From: [REDACTED]
Sent: 23 March 2017 10:05
To: Planning.Responses
Subject: RE: Planning Consultation on: A/44/17/OUT

App No: A/44/17/OUT

Address: Land west of Brook Lane and South of A259 Angmering BN16 3JL

Proposal: Outline application (with all matters reserved) for demolition of existing buildings on site and the erection of a mixed use development comprising 90No. residential units and a care home (Use Class C2 and C3) & ancillary facilities, including railway crossing, together with associated access, car parking & landscaping.

*Figure 5: Water vole evidence found in 2015
(adapted from Urban Edge Environmental Consulting water vole report)*

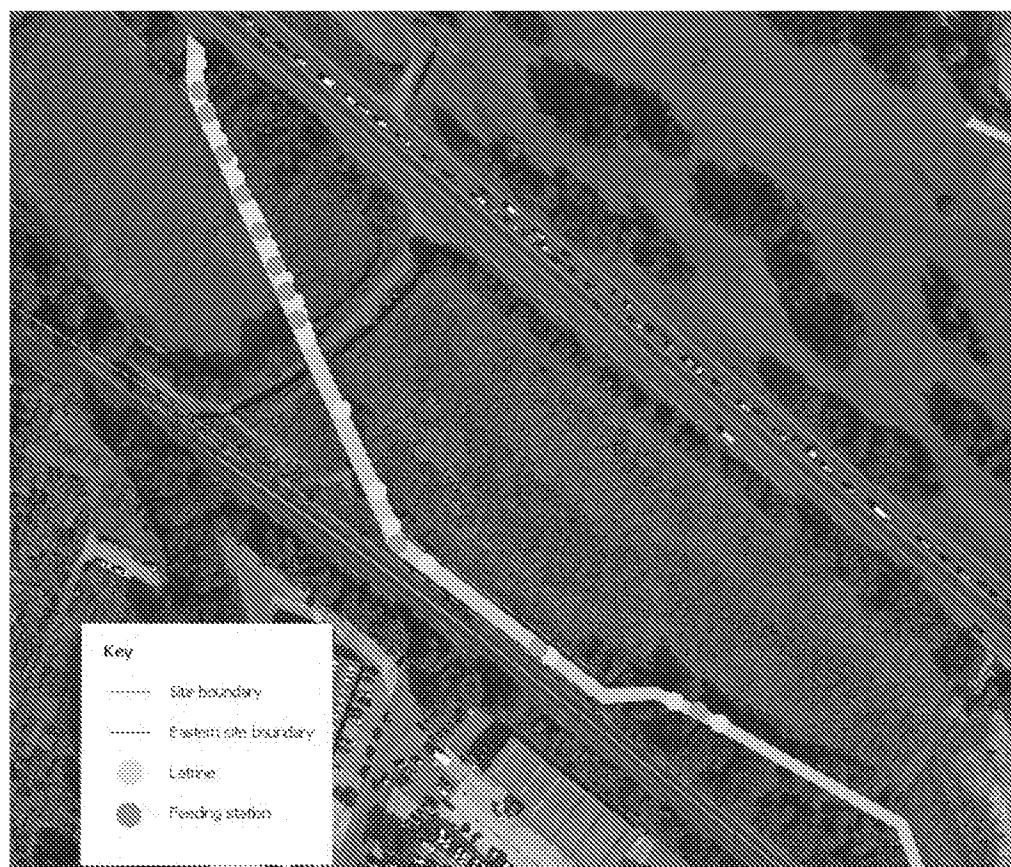
The brook on the eastern boundary of the site has previously been surveyed for water voles and their presence has been established within the brook. A mitigation strategy which was written by Urban Edge Ecology in 2015 is referred to within the Preliminary Ecological Appraisal (Feb 2017) for works which would widen the road and works to the bridge. Please can the applicant provide this full mitigation strategy and ensure that this is tailored to the current proposals. This strategy will need to include details of the full mitigation measures and details of habitat improvements / recreation which will be made for water voles as part of the mitigation. We require that this is submitted for our approval prior to determination.

Photograph 13:
The crack in the trunk of the walnut tree in the back garden of the house – low roosting bat potential.

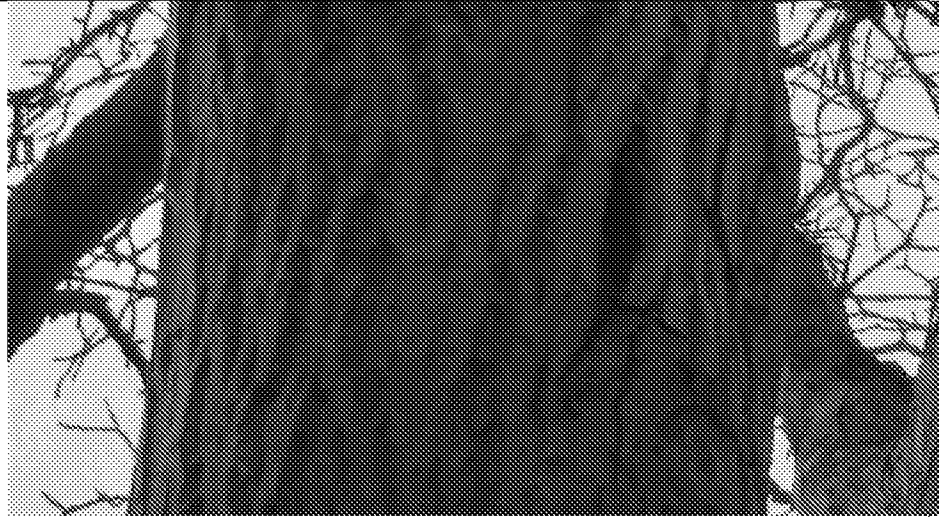
Two trees have also been identified as having bat roosting potential including an England Walnut in the garden of the house and a large Oak tree at the eastern end of the central field. If these trees are being retained we require that a buffer zone is included around them to ensure they remain undisturbed. If however any works are required on these trees further emergence survey work will be required and as detailed above will need to be submitted for approval prior to determination.
